From: Kylie O'Brien Pratt <Kylie.O'BrienPratt@transgrid.com.au>
Sent: Wednesday, 26 July 2017 3:31 PM
To: Chloe Dunlop
Cc: Kenson Ho; Lauren Vine
Subject: TransGrid comments: Notice of Section 96(1A) Modification Request - Prestons Warehouse and Distribution Centre (SSD 7155 MOD 2) - Liverpool LGA
Attachments: SSD 7155 MOD 2_Notice of modification request_Transgrid.pdf; TransGrid approval: Propose works at Prestons Industrial Warehouse and Distribution Centre; Marked Up.pdf; Appendix B_ Landscape Drawings SSD 7155.pdf; TG Easement Guidelines for Third Party Development (V10) (2).pdf

From: Nuray Duran [<mailto:Nuray.Duran@planning.nsw.gov.au>]
Sent: Wednesday, 12 July 2017 2:39 PM
To: Kylie O'Brien Pratt
Subject: Notice of Section 96(1A) Modification Request - Prestons Warehouse and Distribution Centre (SSD 7155 MOD 2) - Liverpool LGA

Drawing:
SITE PLAN - COLOURED OVERALL ESTATE PLAN
 Drawn: AA Date: November 2015 Scale: 1:1000 @ A1 1:2000 @ A3
 Project No: 140604 Drawing No: S96 - A 102 Issue: L

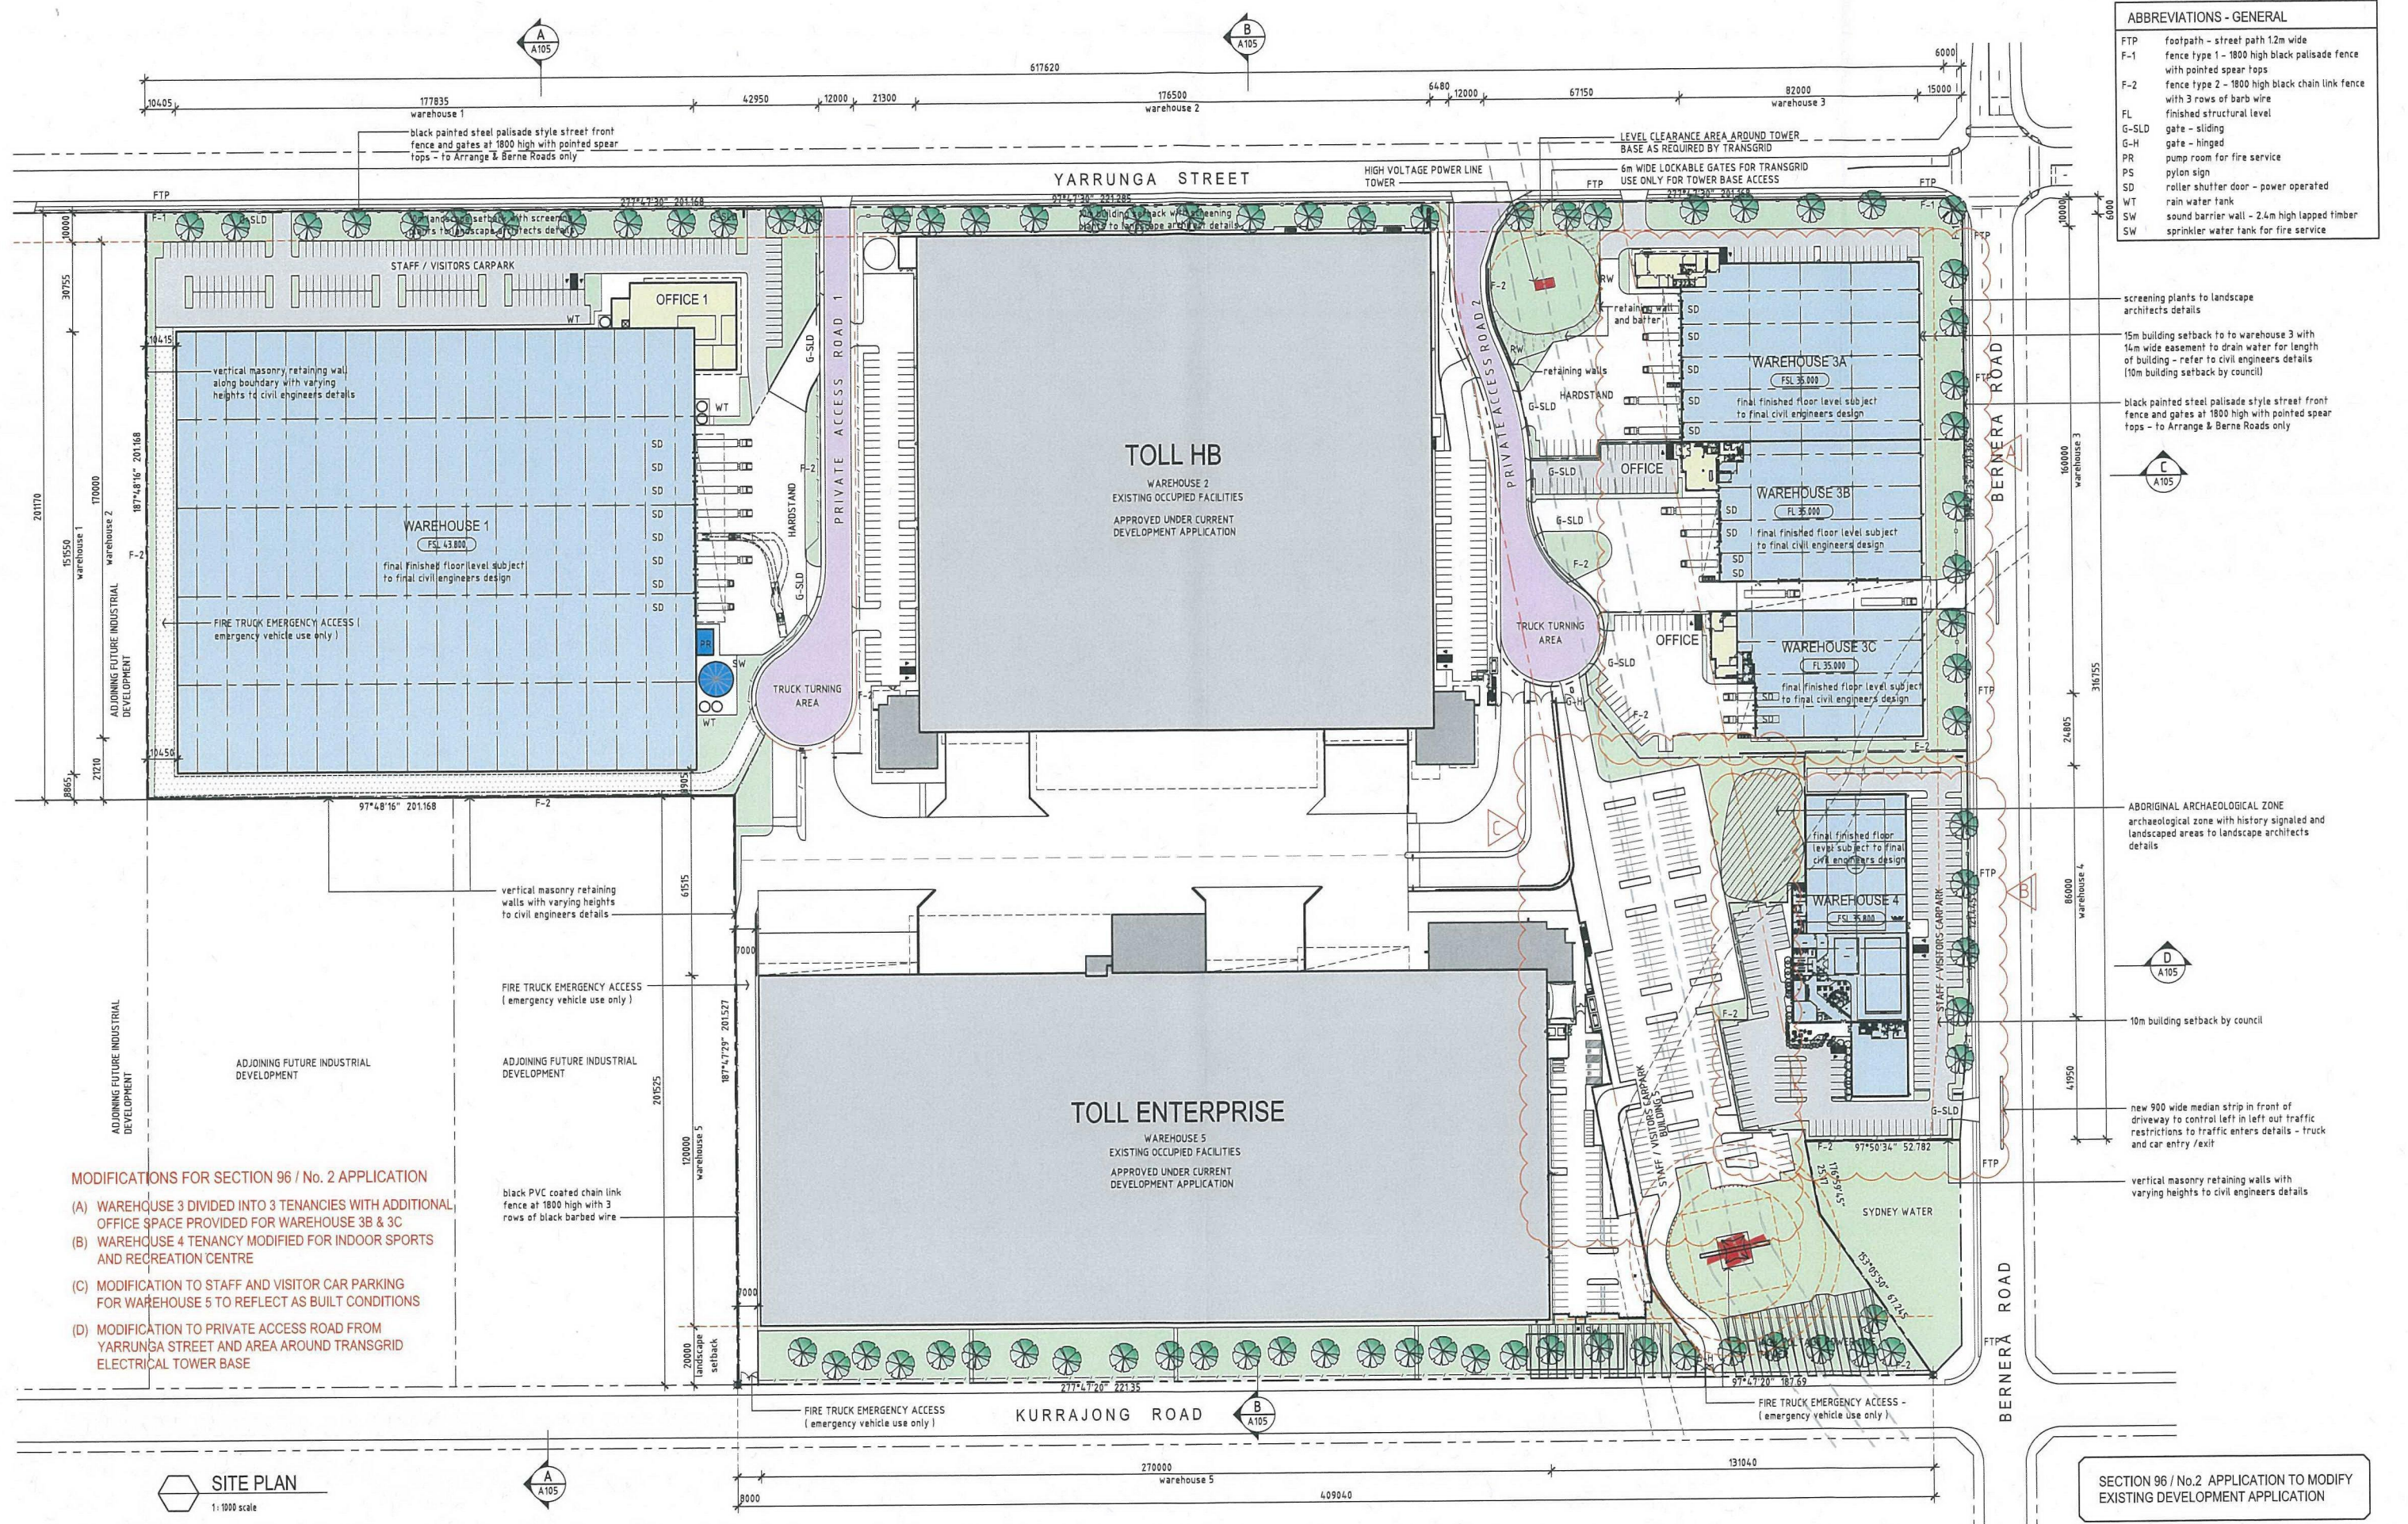
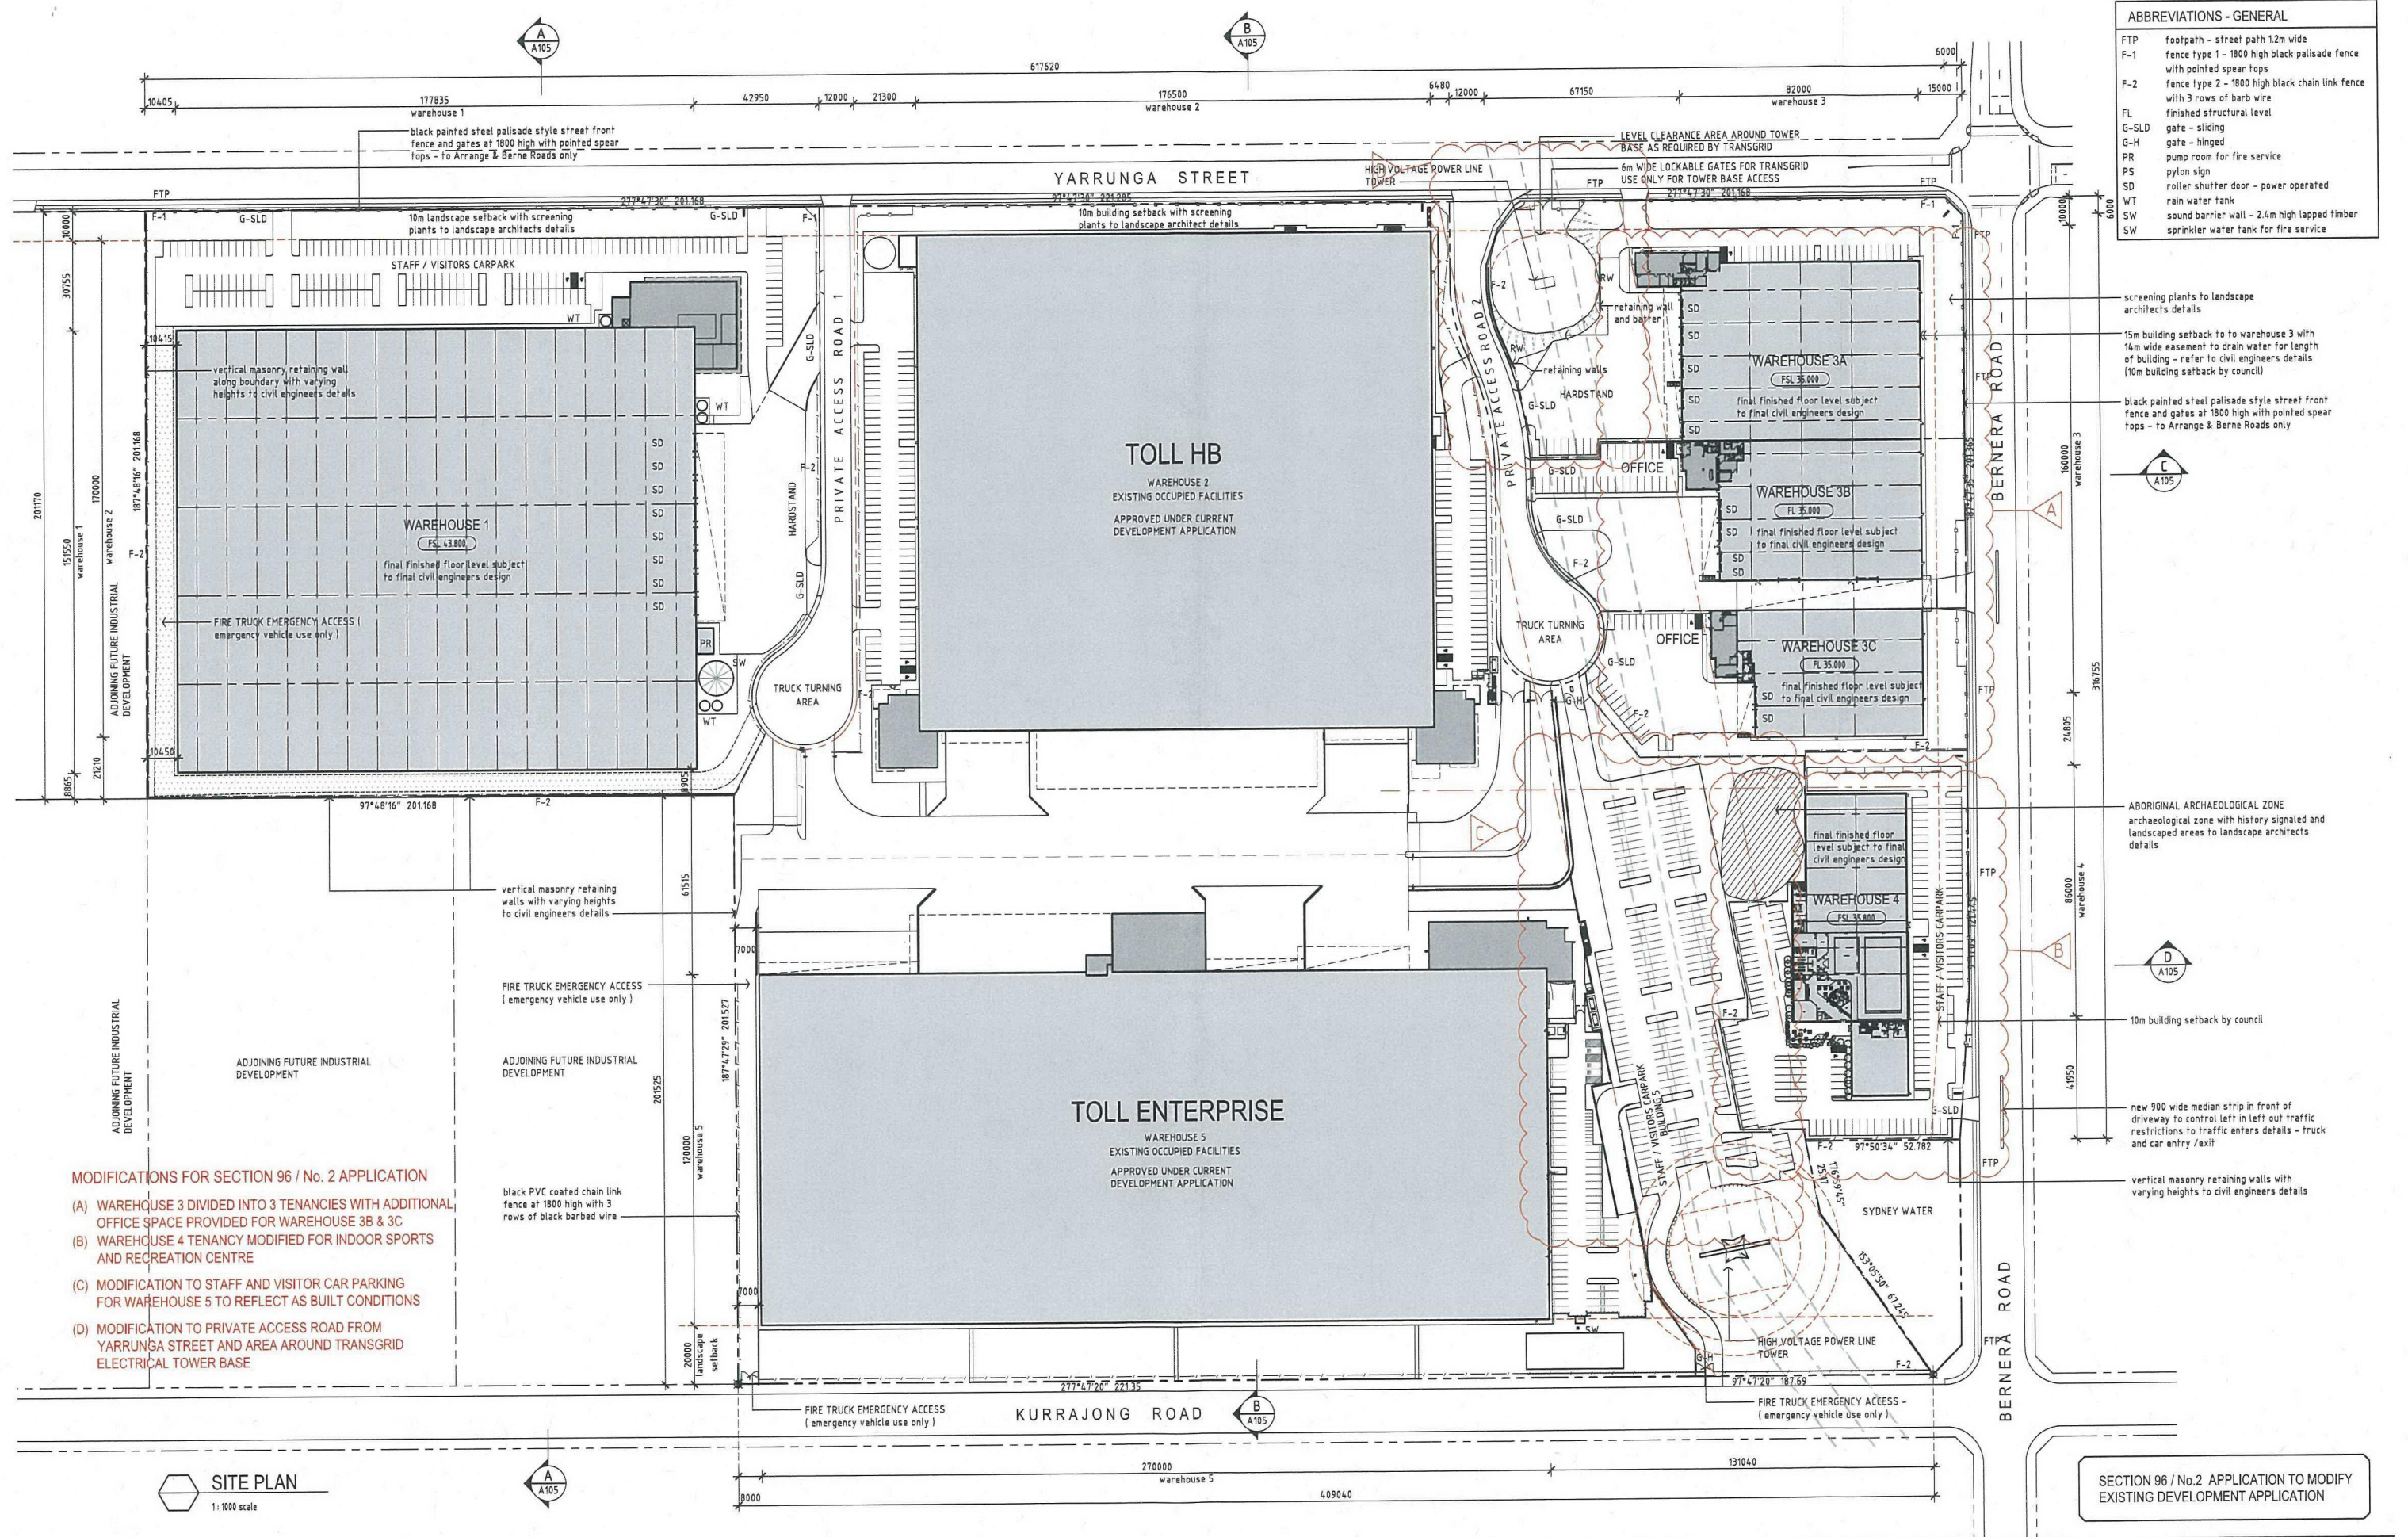
TransGrid objects to this modification application as the landscaping works would interfere with TransGrid's access to the tower. The design of the area surrounding TransGrid's northern tower is unacceptable and is different to the previously approved design which was developed in consultation with TransGrid. The attached marked up drawing was previously provided by the applicant's representative in response to the issues raised by TransGrid. The original design would have prevented TransGrid from being able to access our towers and the proposed retaining wall was agreed to be shortened at the north-west corner of the property near the tower to allow us access.

Access to TransGrid's transmission lines, stanchions and easement must be maintained at all times. Accessways/roads within the easement must be able to safely withstand the 40 tonne load capacity of TransGrid's maintenance vehicles.
